From: [Barbie McQuay](#)
To: [Zach Torrance-Smith](#); [Julia Sargeant](#); [Mark Mcquay](#)
Subject: Culvert instrument Parcel 558535
Date: Thursday, April 23, 2026 4:32:40 PM
Attachments: [gmail_images20260423_161207.png](#)

I am writing to formally express my opposition to the proposed culvert addition detailed in the attached notice. The current plans, which support the construction of a 992-square-foot building and a 600-square-foot detached garage, would disrupt the natural environment and the runoff creek that runs through my property line.

LOT 9 HYAK ESTATES 2 GRADING DESIGN
RYAN PAZARUSKI
SITE PLAN

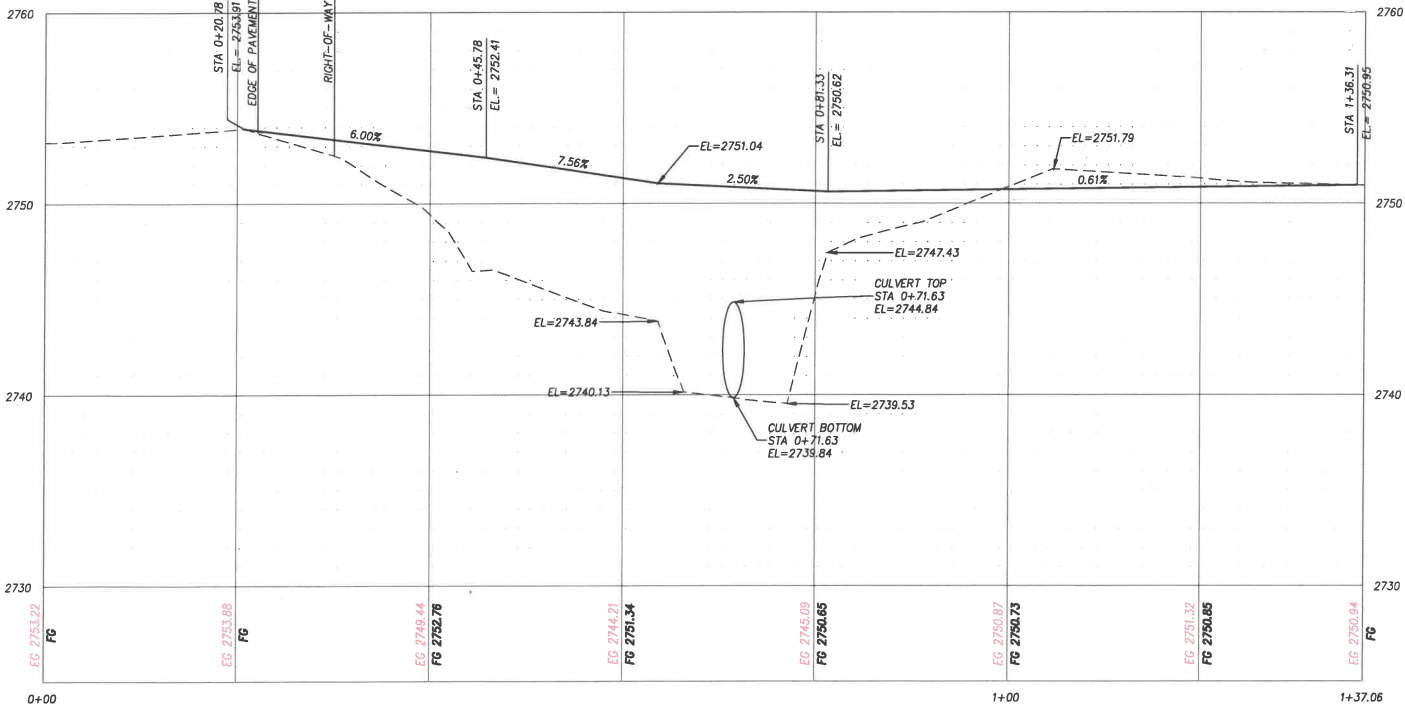
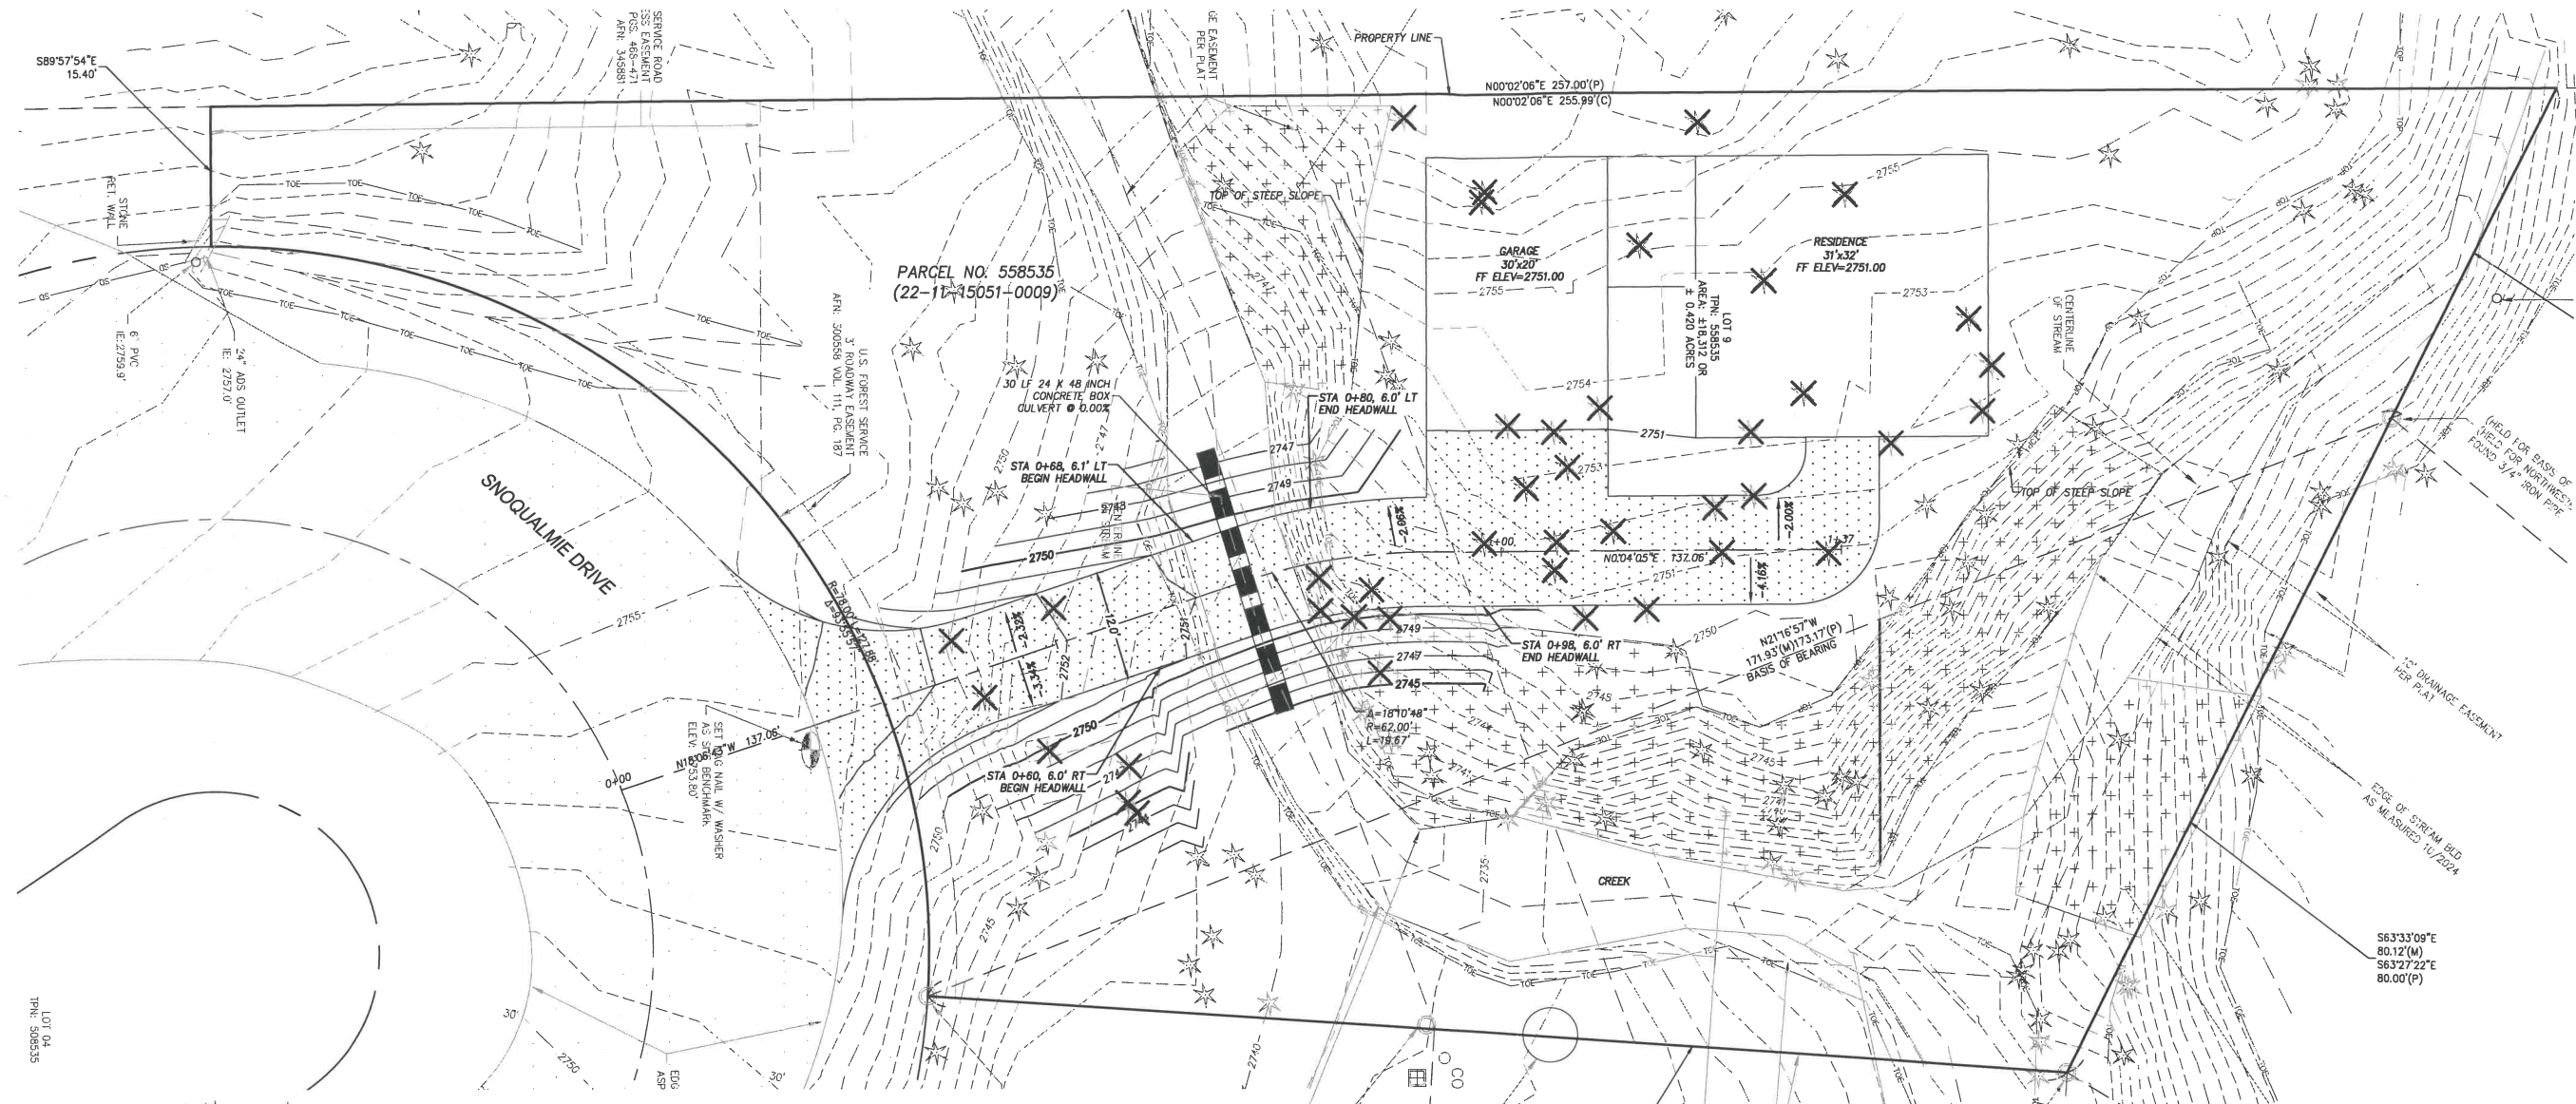
My property is Parcel #13, located at the corner of Garmisch Place and Cascade Place. I am concerned that any modification to the waterway will cause significant drainage issues for my property downstream. During seasons of high snowmelt, this stream carries a much larger volume of water than your current design considers

I strongly encourage a redesign of these plans that ensures NO movement or redirection of the existing runoff.

One of the desirable elements my plot had when we purchased it 27 years ago was and is the stream in the manner that it is now. I oppose any culvert installed or redirection of the runoff.

Creat some other method the bring cars in that doesn't threaten the natural environment, habitat of wild life and scenic beauty at this parcel.
